Online Comment

Application H09-0796-25
Location Land East of Forest Way Holbeach Spalding
Proposal Proposed Erection of 2 Bungalows

Date Submitted 22-09-25
For/Against Objections

PROPOSED SITE PLAN
scale 1:200

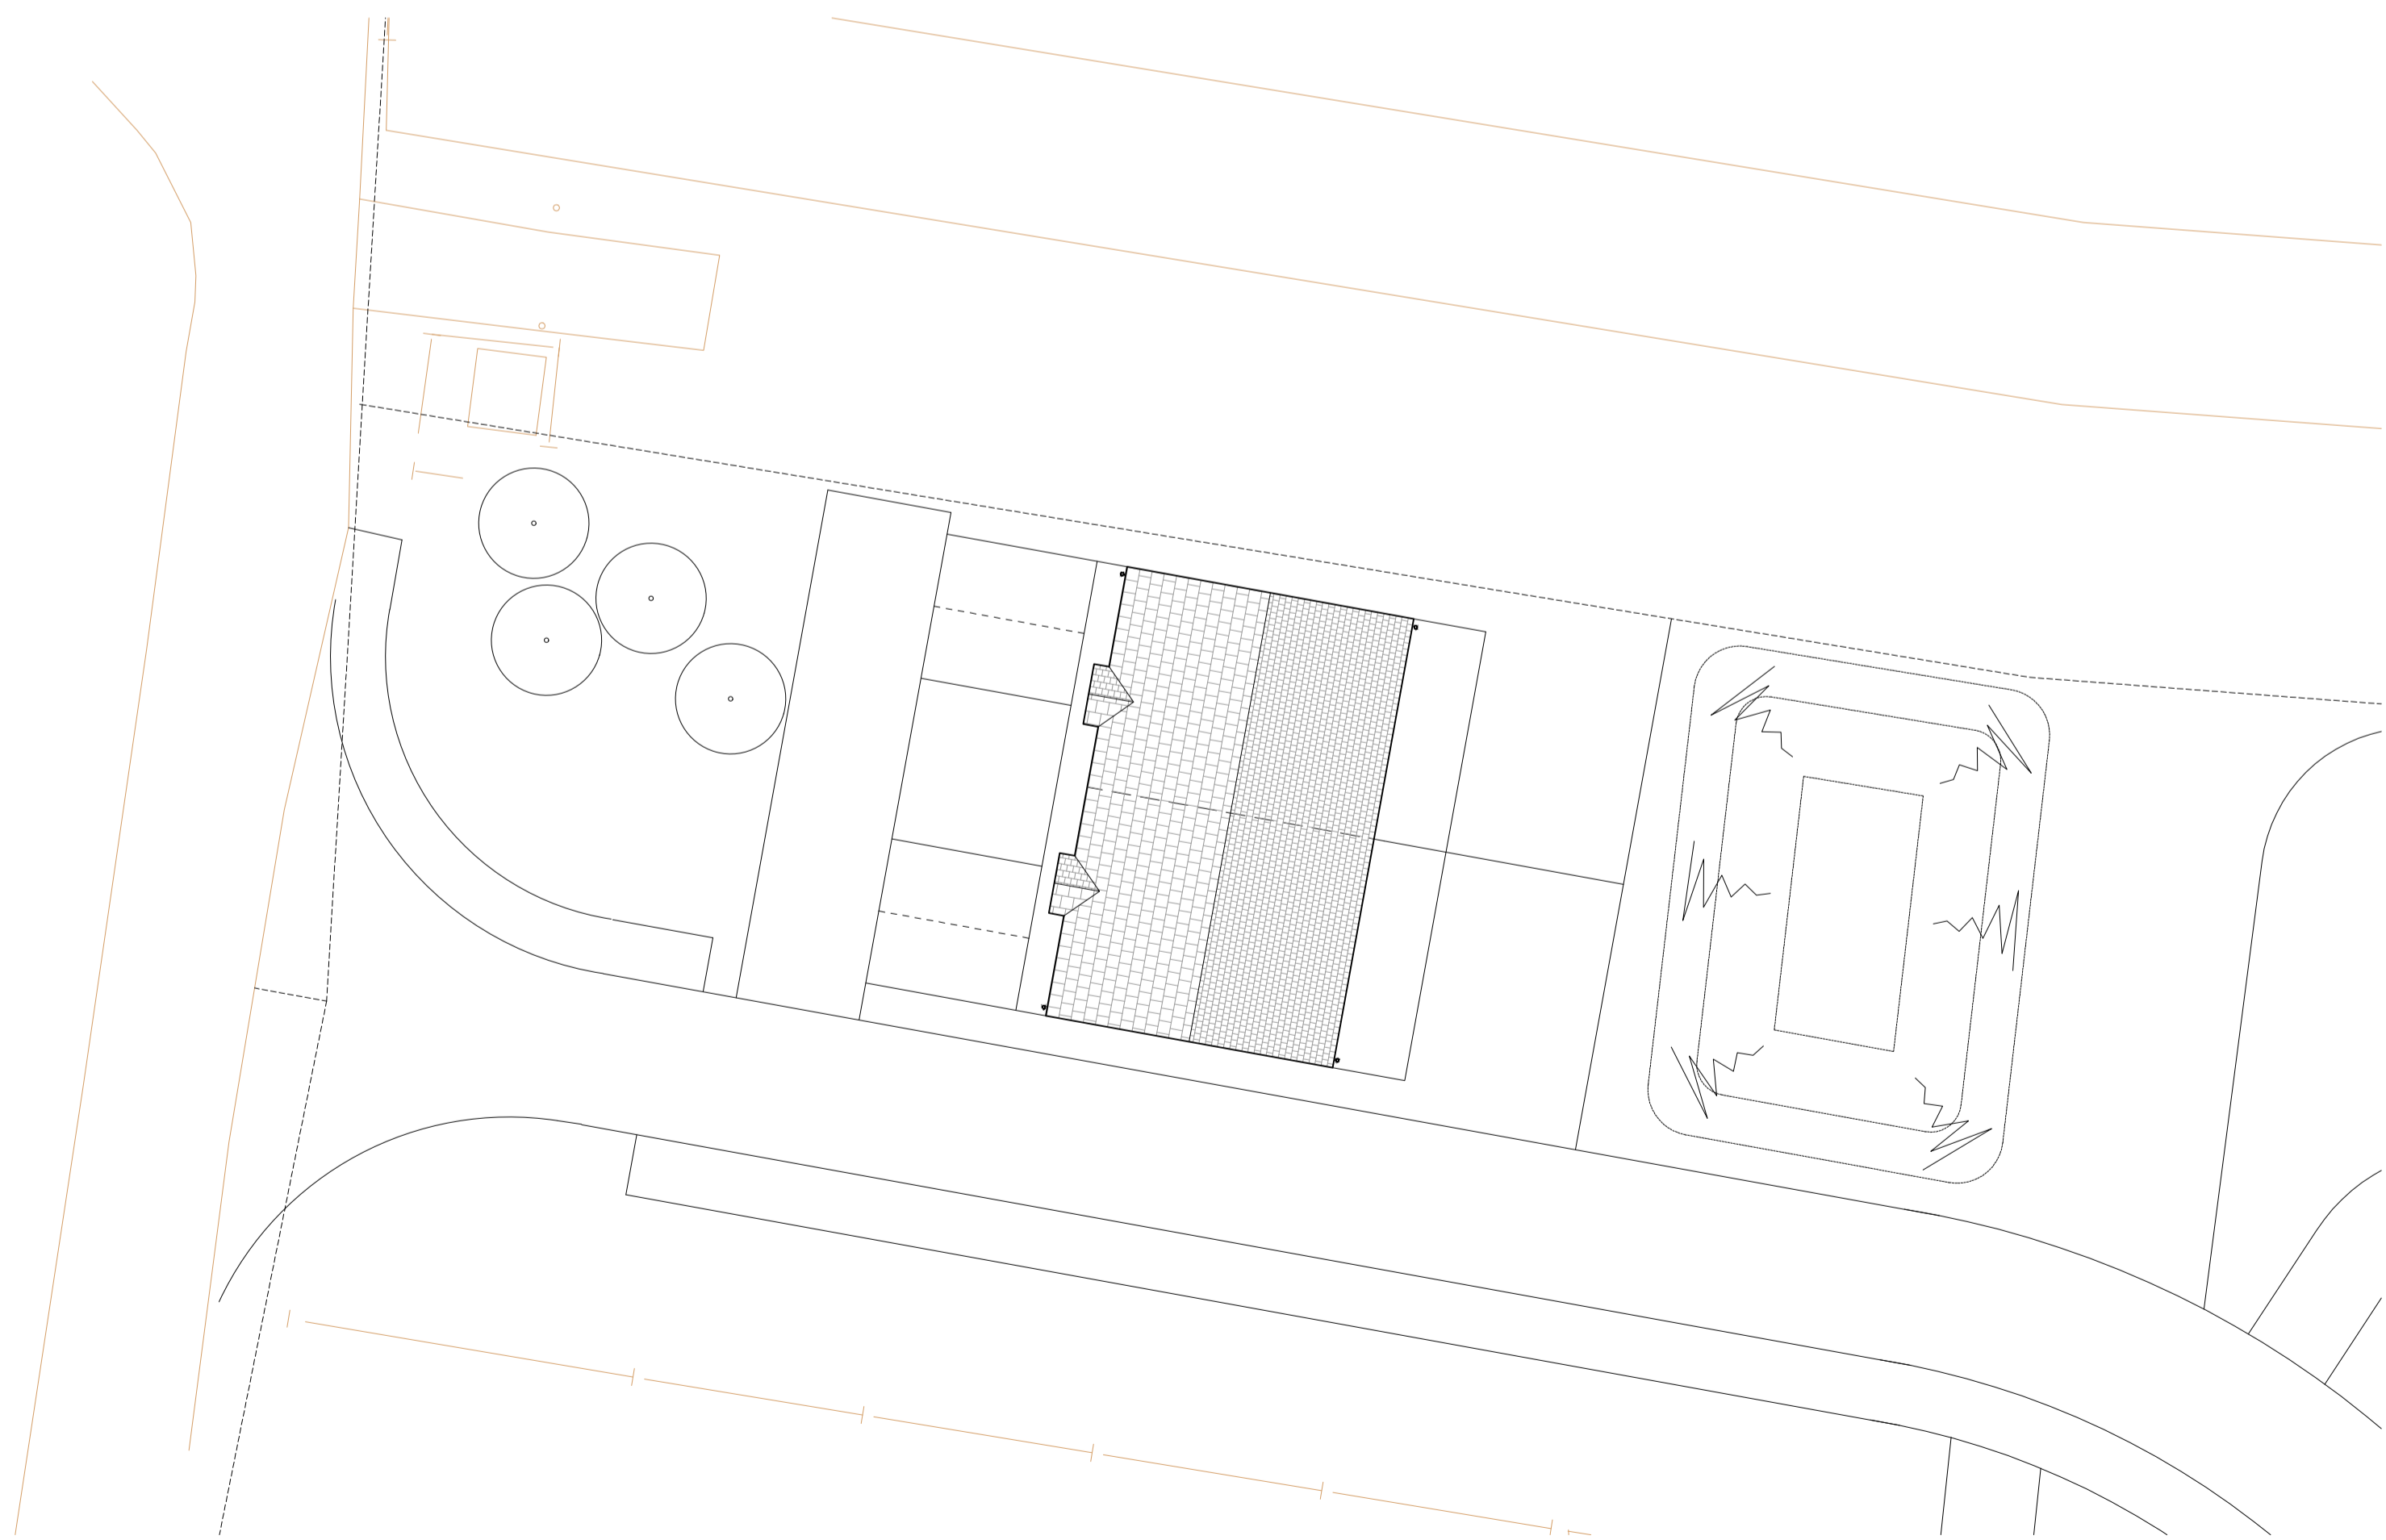
This isn't an application I can support as it will change the aesthetics of the estate. As the green space at the front is in line with the design of another estate close by, I would assume it was part of the original planning application, as this is the green space for the estate. Therefore to add two bungalows is out of keeping with the design, and would limit the green space available to the residents.

Also the entrance to the bungalows is close to the junction, which currently has a fairly clear access view, and the number of dwellings on the estate means that it is a busy road so could cause a problem. There is also the issue that two very small bungalows, with a design that looks very out of keeping with the rest of the properties, each with 2 parking spaces will look completely incongruous dropped onto a space clearly not intended to be built on. I have received 3 objections to the proposal from residents and I'm in agreement with their concerns.
